## Loftus & Gipps St, Concord

### DA Stage Accessibility Assessment Report – BCA 2022

### Report 2025/1867 R1.1

Prepared for LFD Concord Pty Ltd  
January 2026

Scale: @ A1 / **1 : 200**

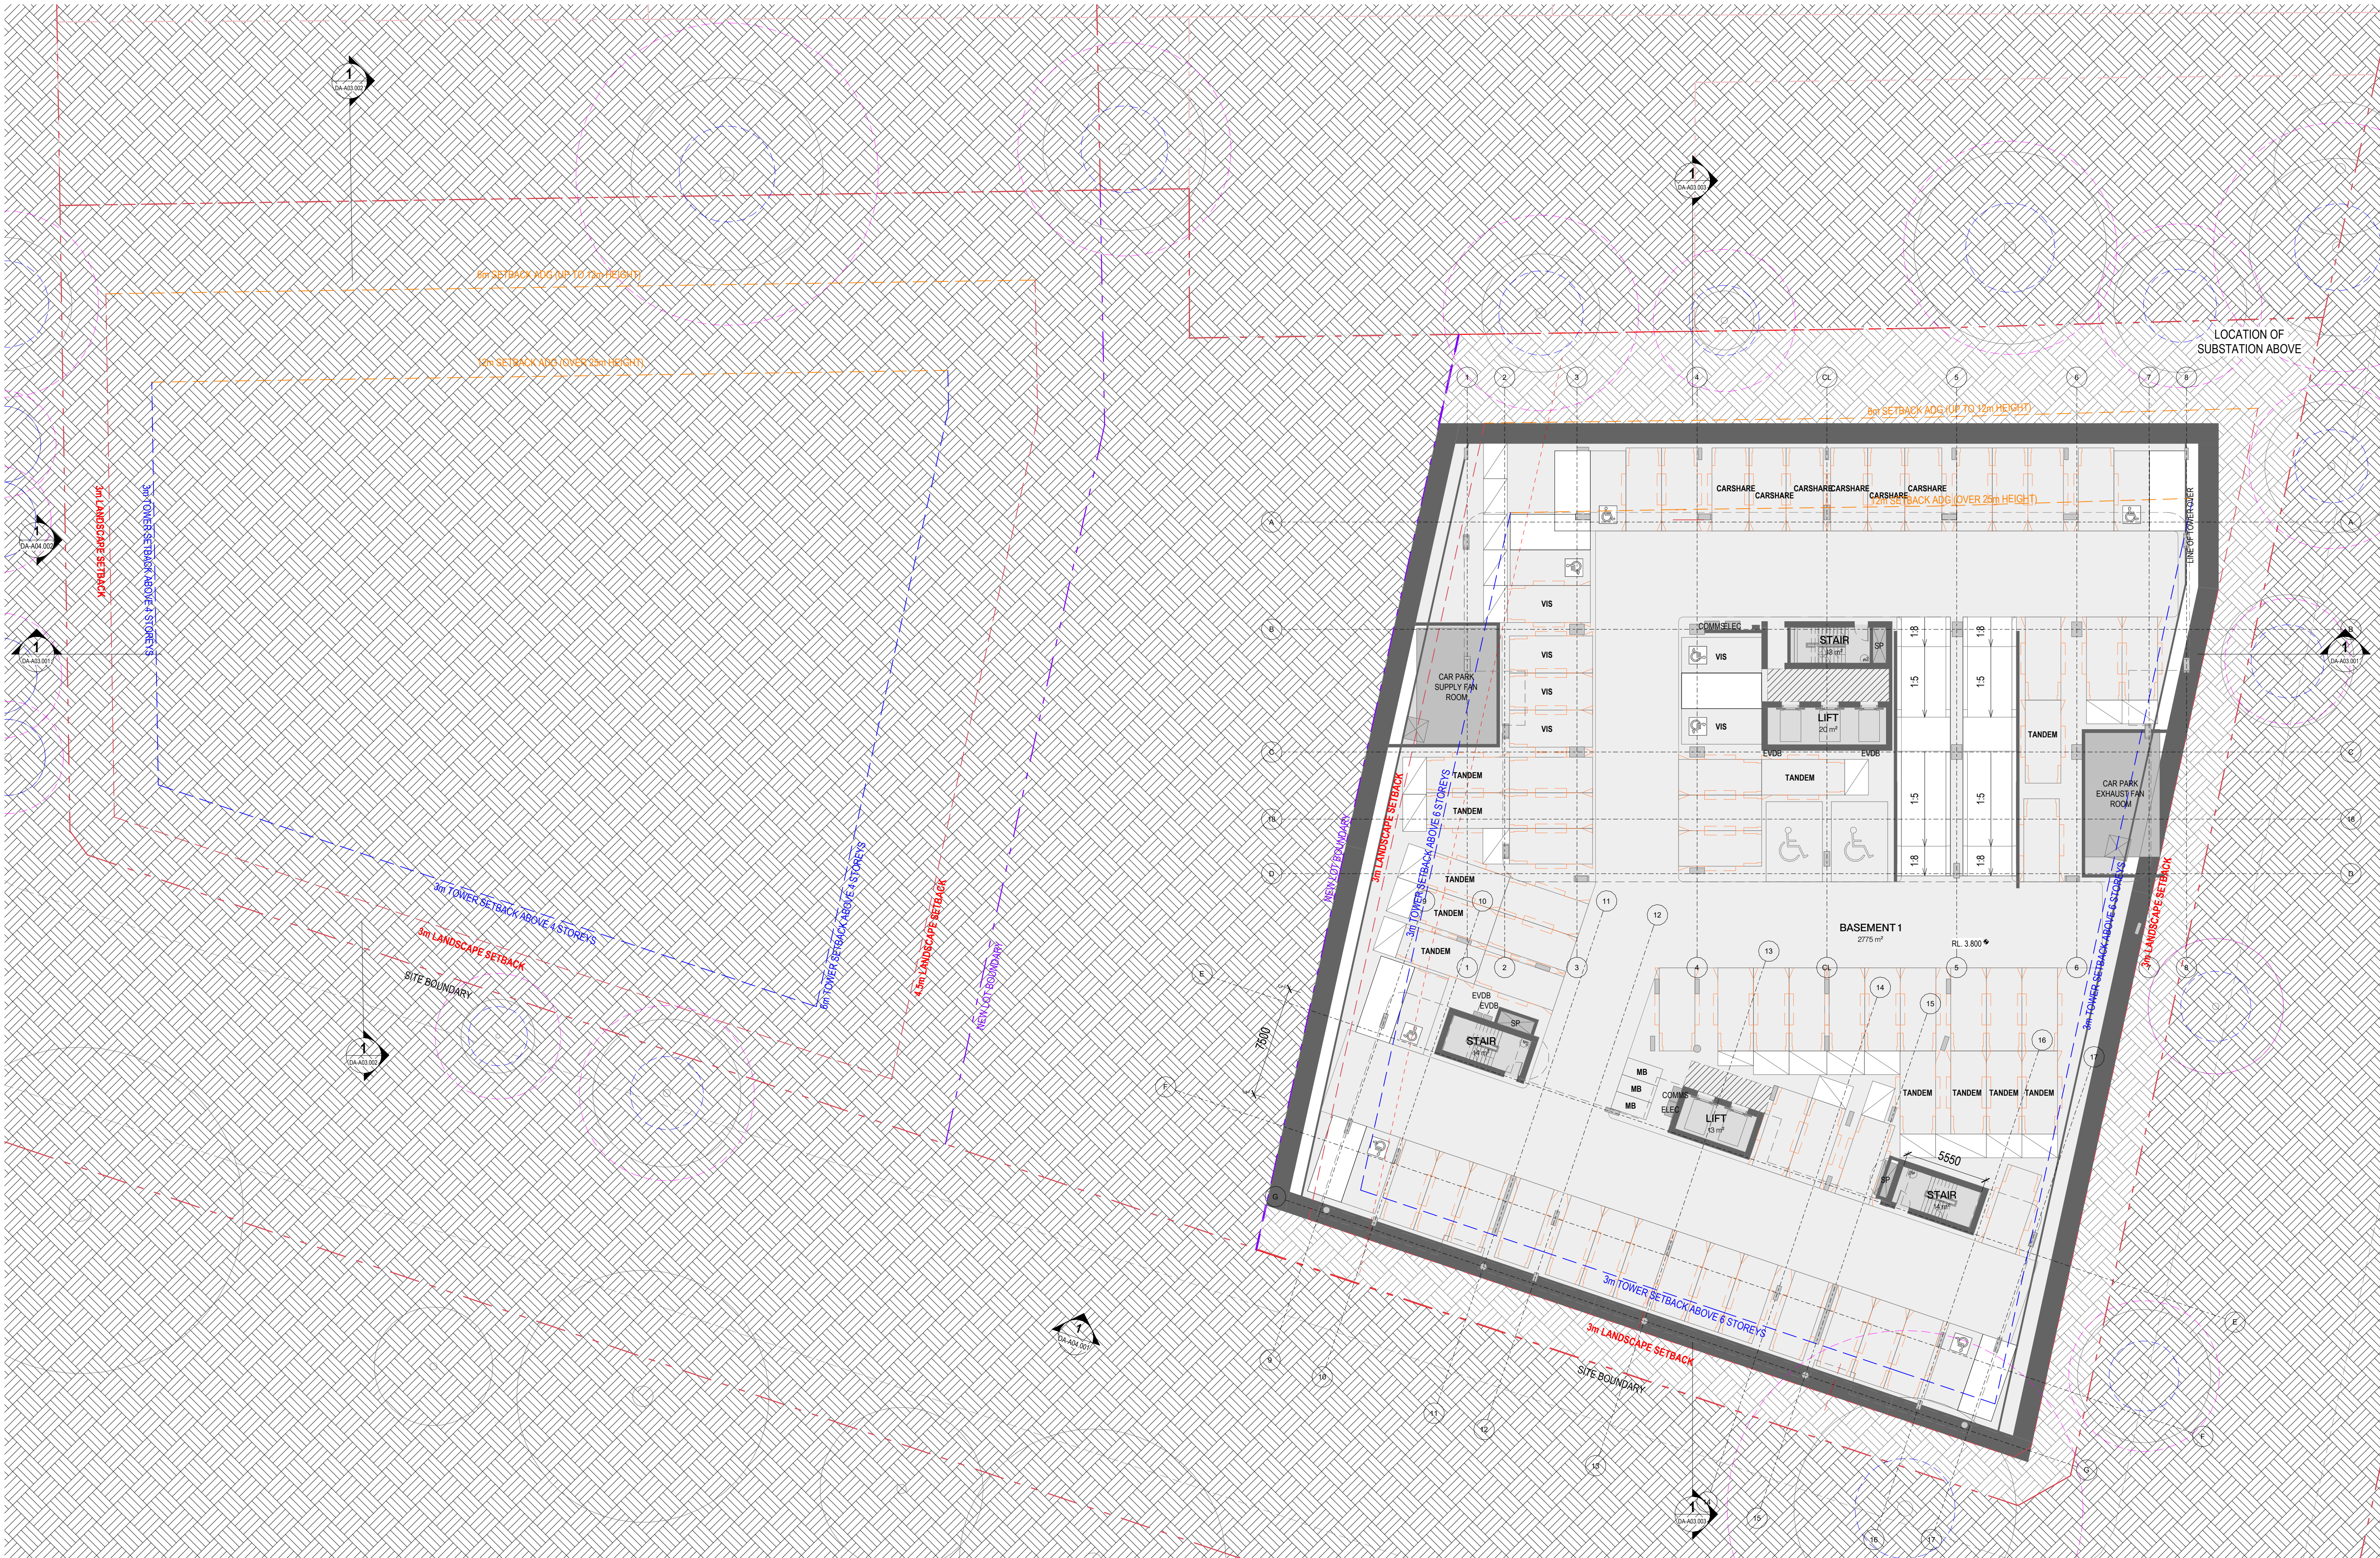
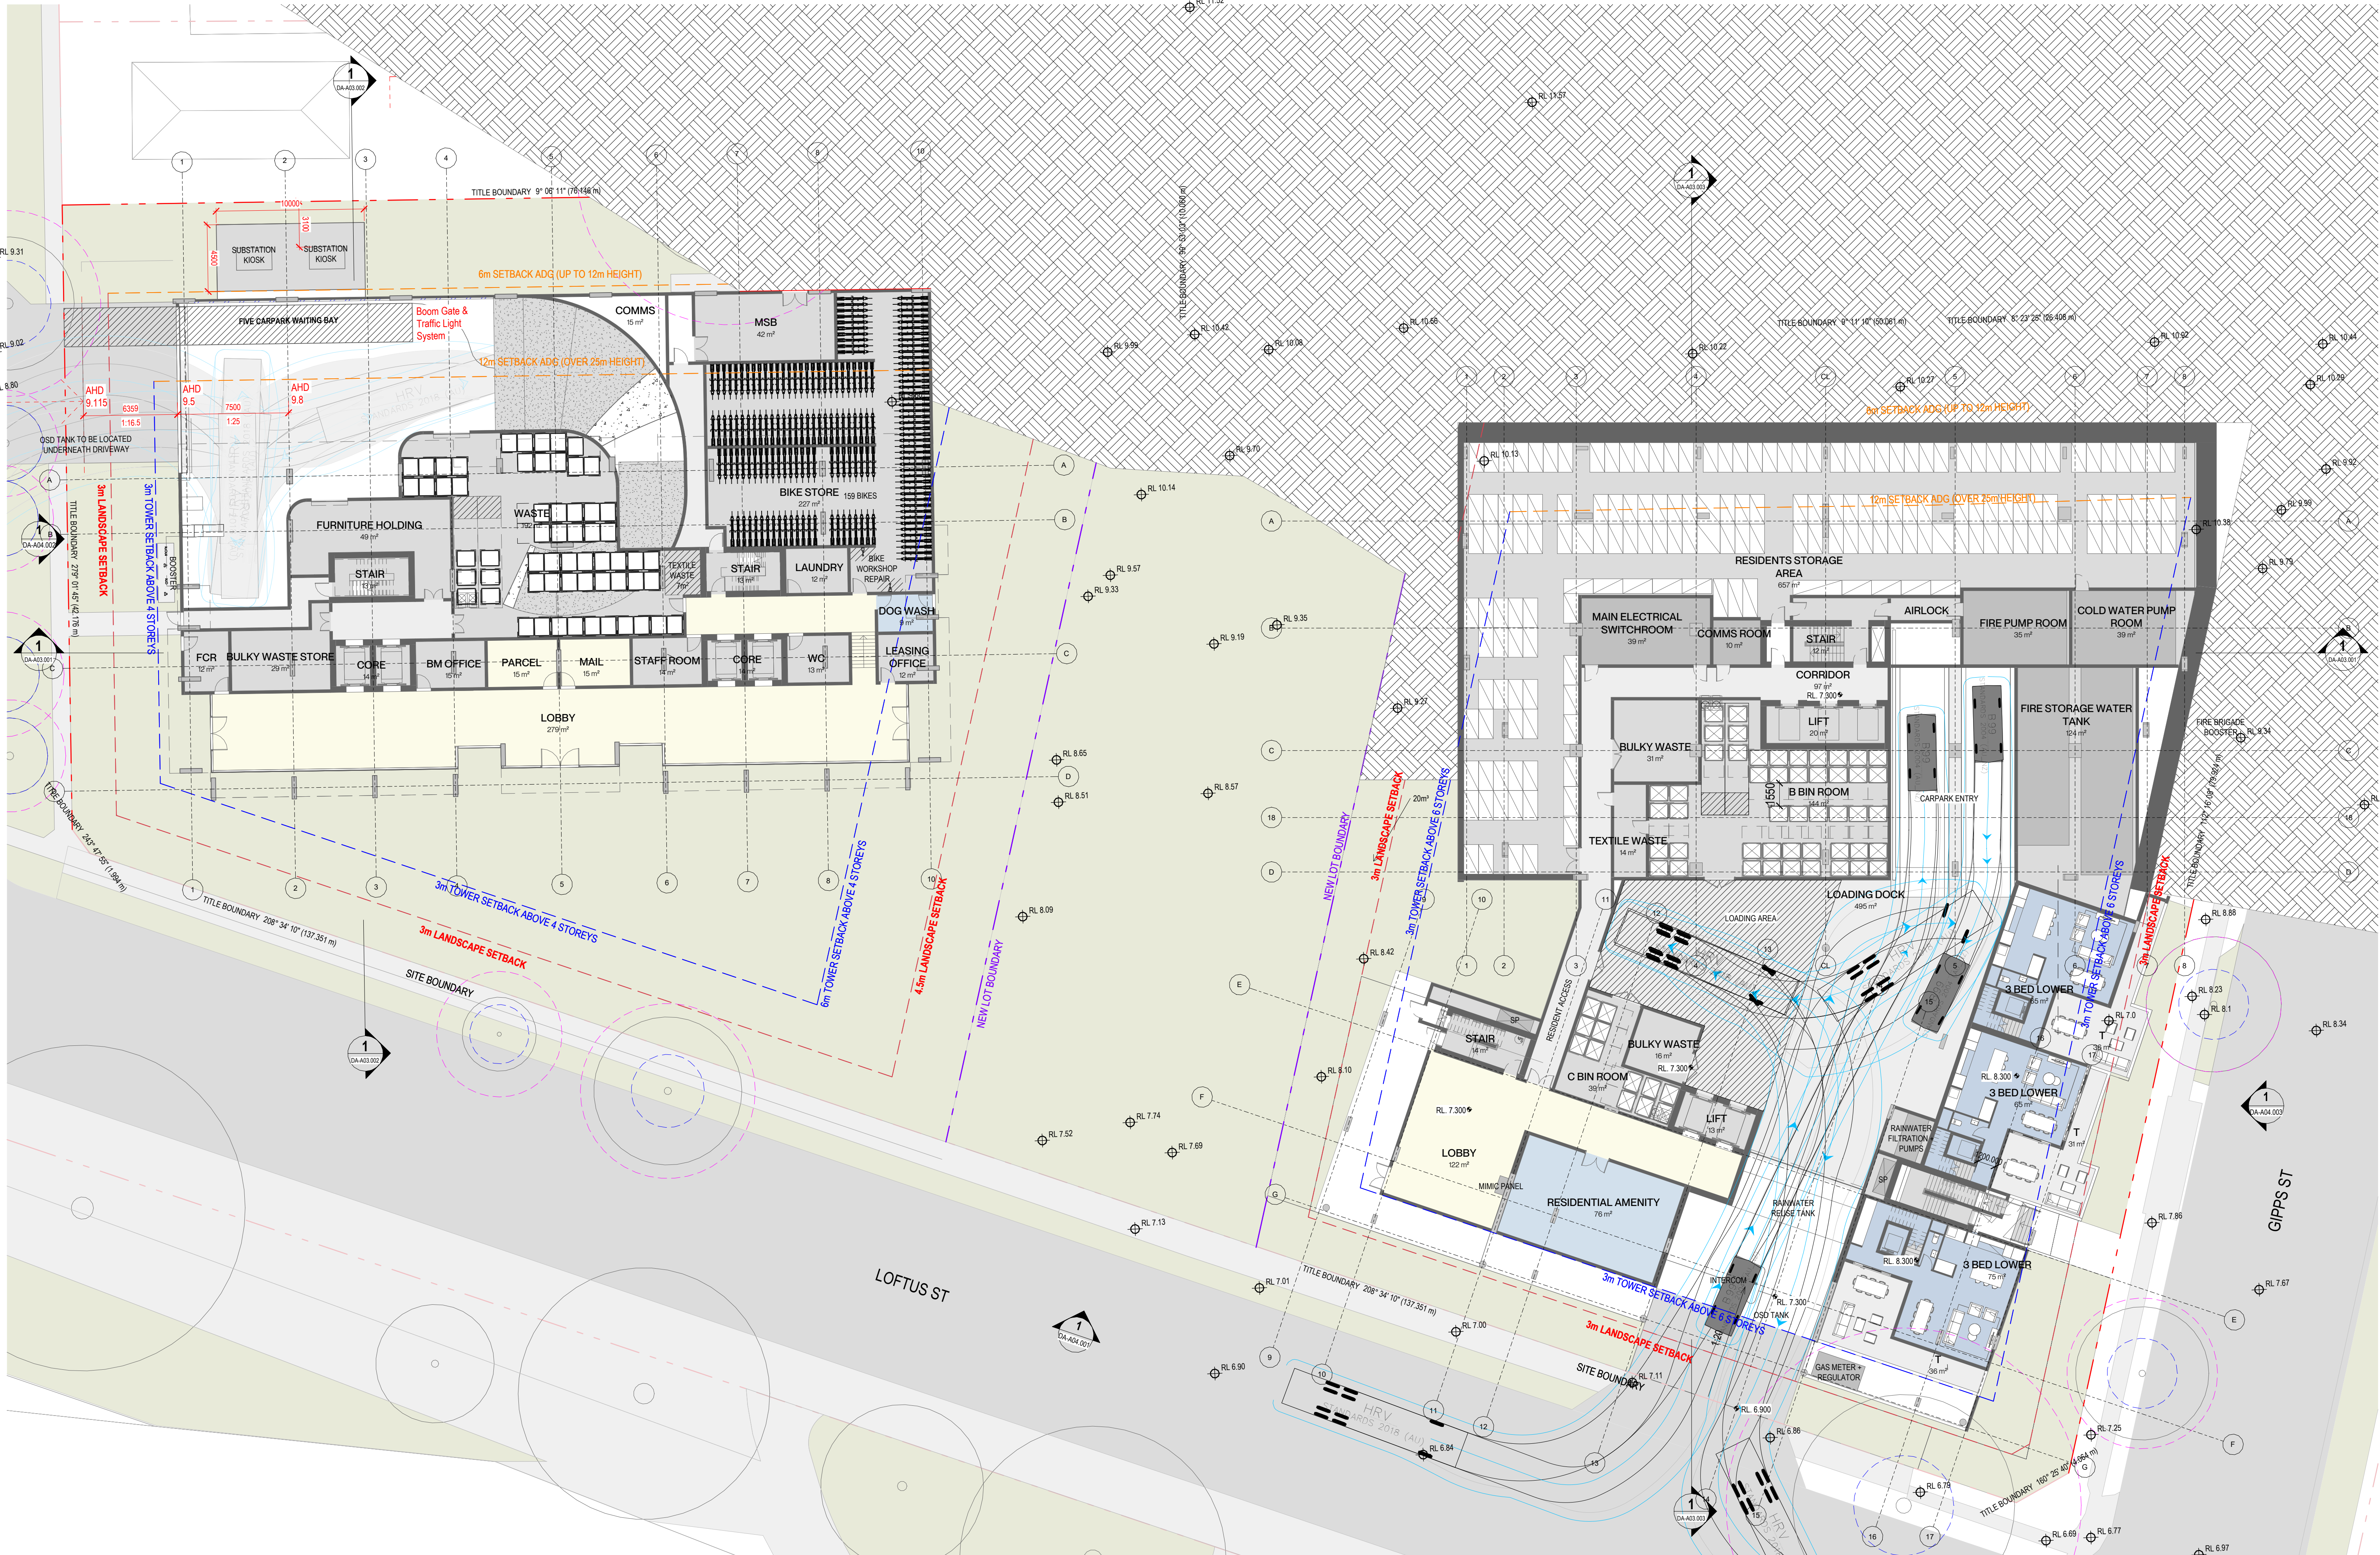
<b>Private Car Accommodation</b>			
<b>3.7.2</b>	Carparking space or garage min area 6.0x3.8m	There will be 34 adaptable units provided. The basement parking plans have provisioning for 34 accessible spaces that can readily achieve compliance with AS 2890.6. It is noted that AS 4299 requires an adaptable space to be 3.8m wide, therefore the adaptable units must also own the shared zone under the strata scheme to ensure the 3.8m wide space is complied with. This shall be confirmed at the CC stage.	Compliance Readily Achievable
<b>Accessible Entry</b>			
<b>4.3.1</b>	Accessible entry	To comply with door circulation spaces under AS1428.1, the entry door to the adaptable unit must have a minimum clear opening of 850mm and comply with AS 1428.1-2021 circulation spaces.  The post adaptation plans can readily achieve compliance with this clause with the exception of wheelchair circulation to airlock area – plans indicate approx. 1490mm whereby AS1428.1-2021 requires door circulation to be not less than 1670mm (latch side approach, door opens towards user).	Does Not Comply – Further design development required at CC stage
